Harnett County Government Complex
307 W. Cornelius Harnett Boulevard
Lillington, NC 27546

September 6th, 2024

RE: Existing Tank Application #SFD2406-0034

SITE PLAN

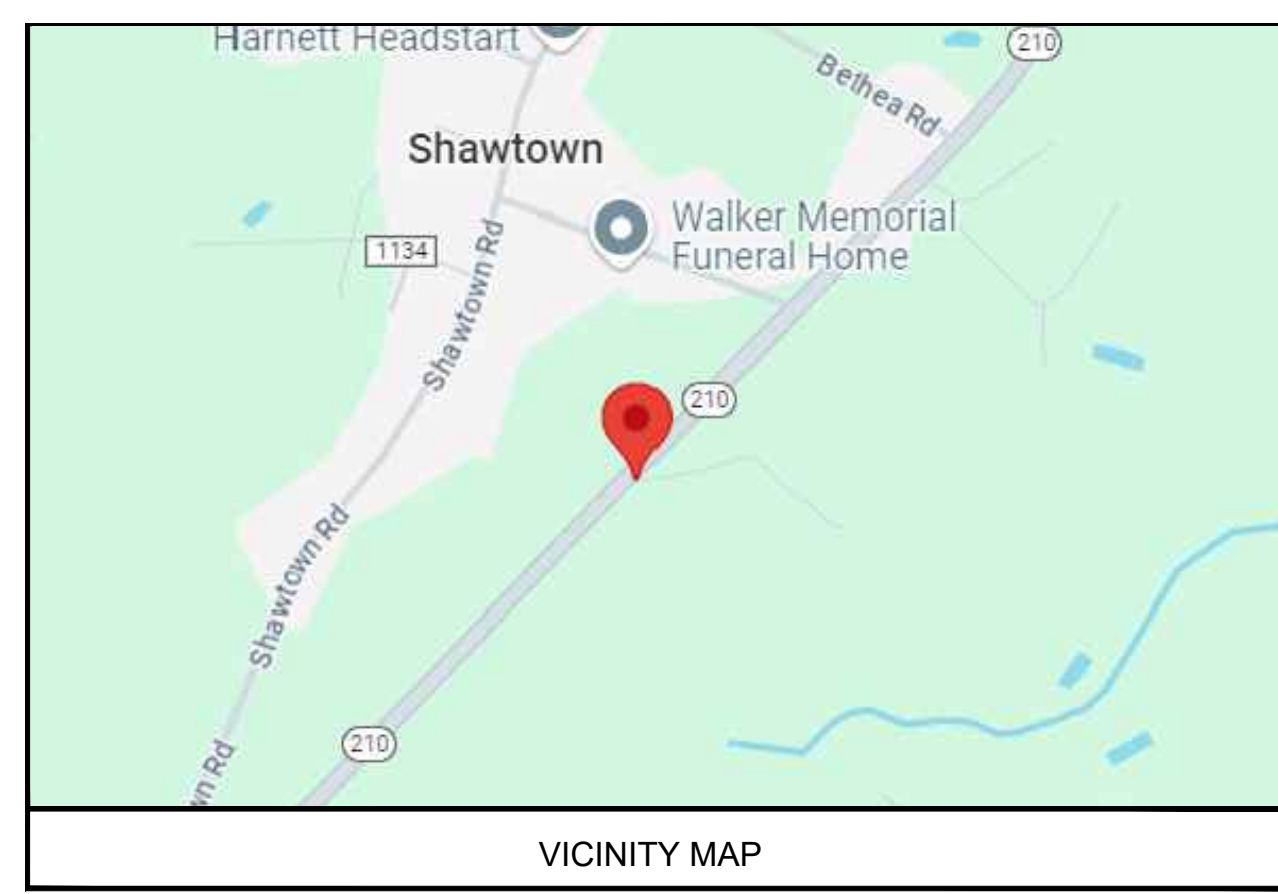
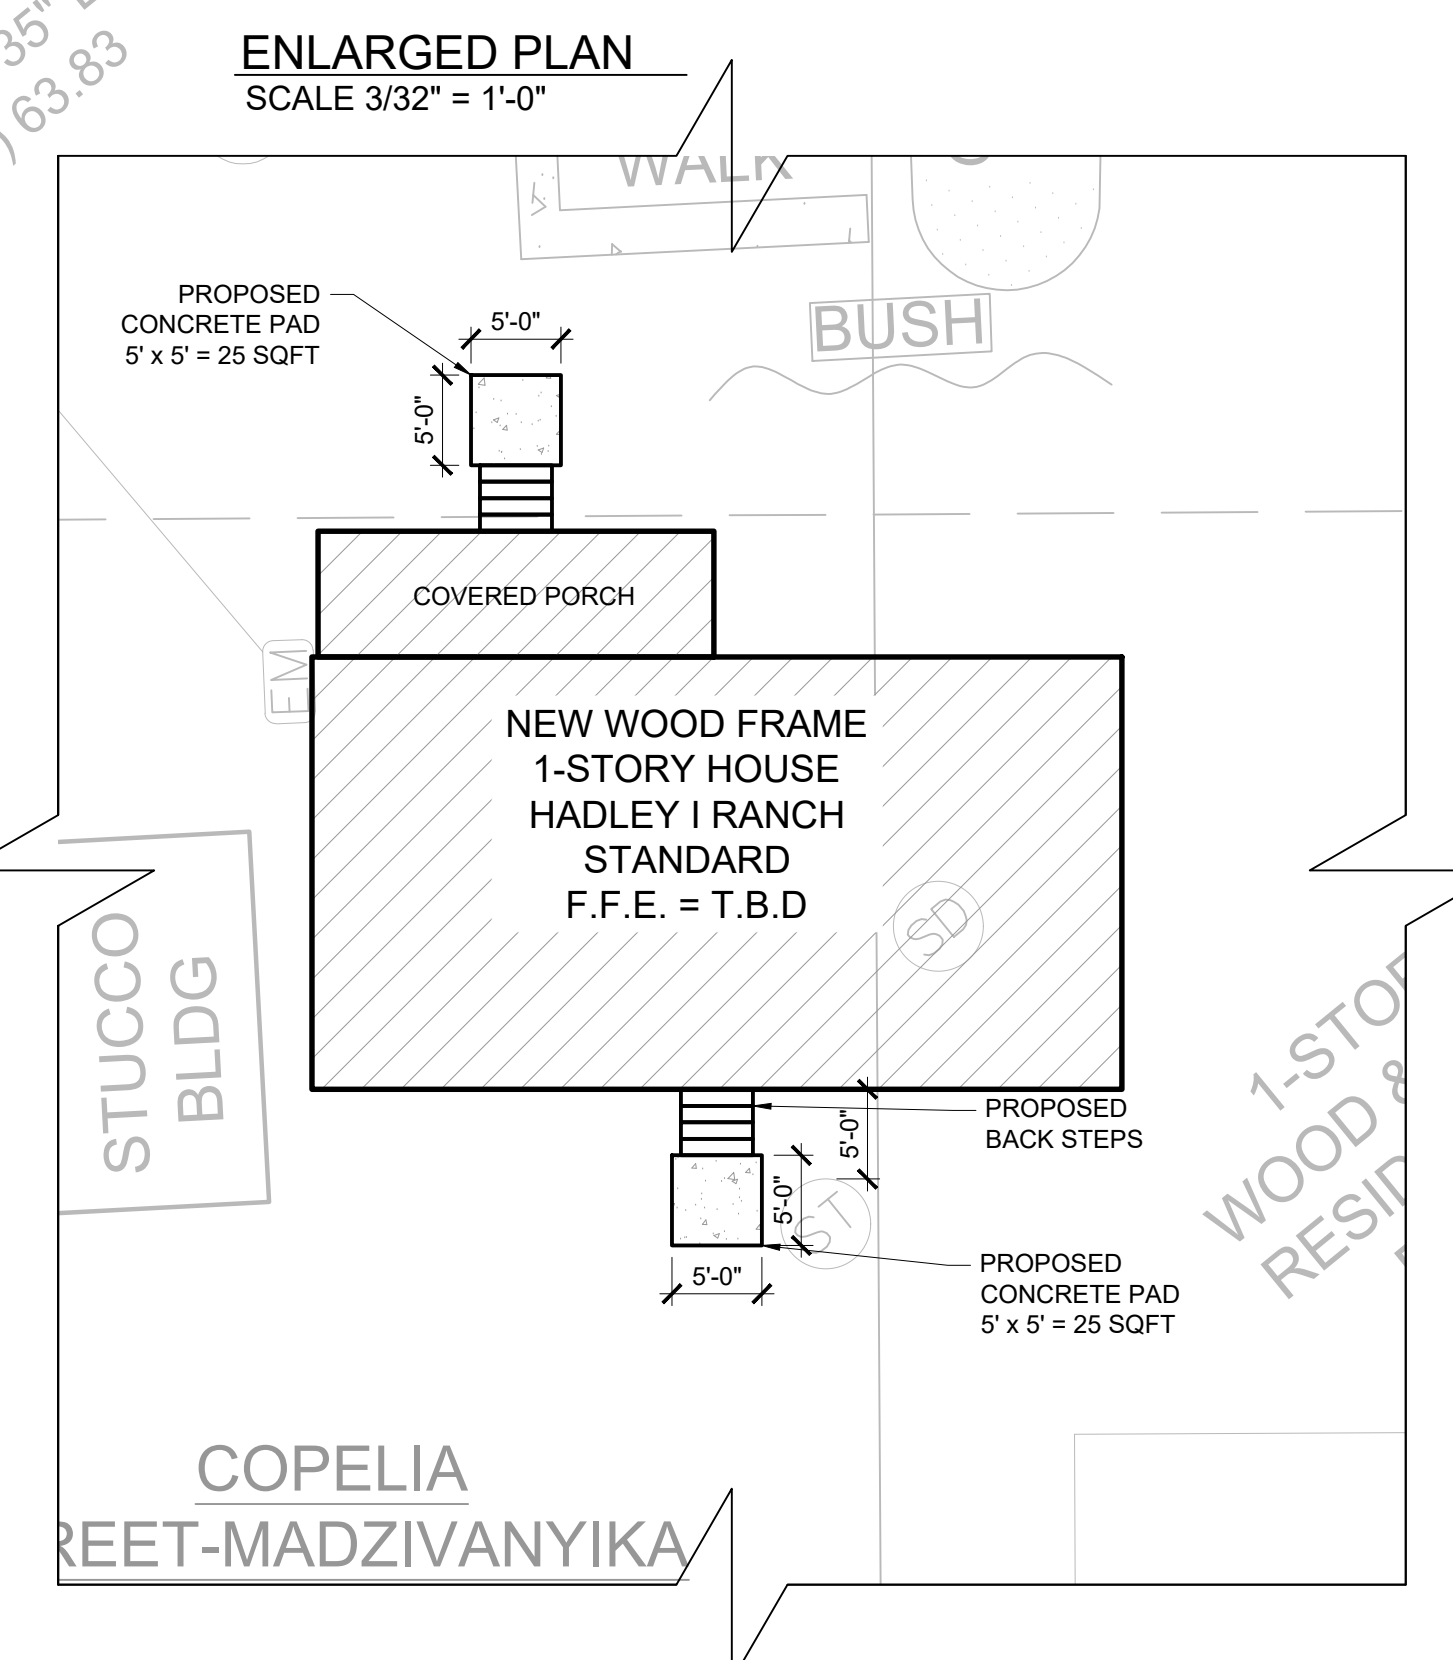
3. Need site plan

4. Other – Will need property irons, property lines and drain lines.
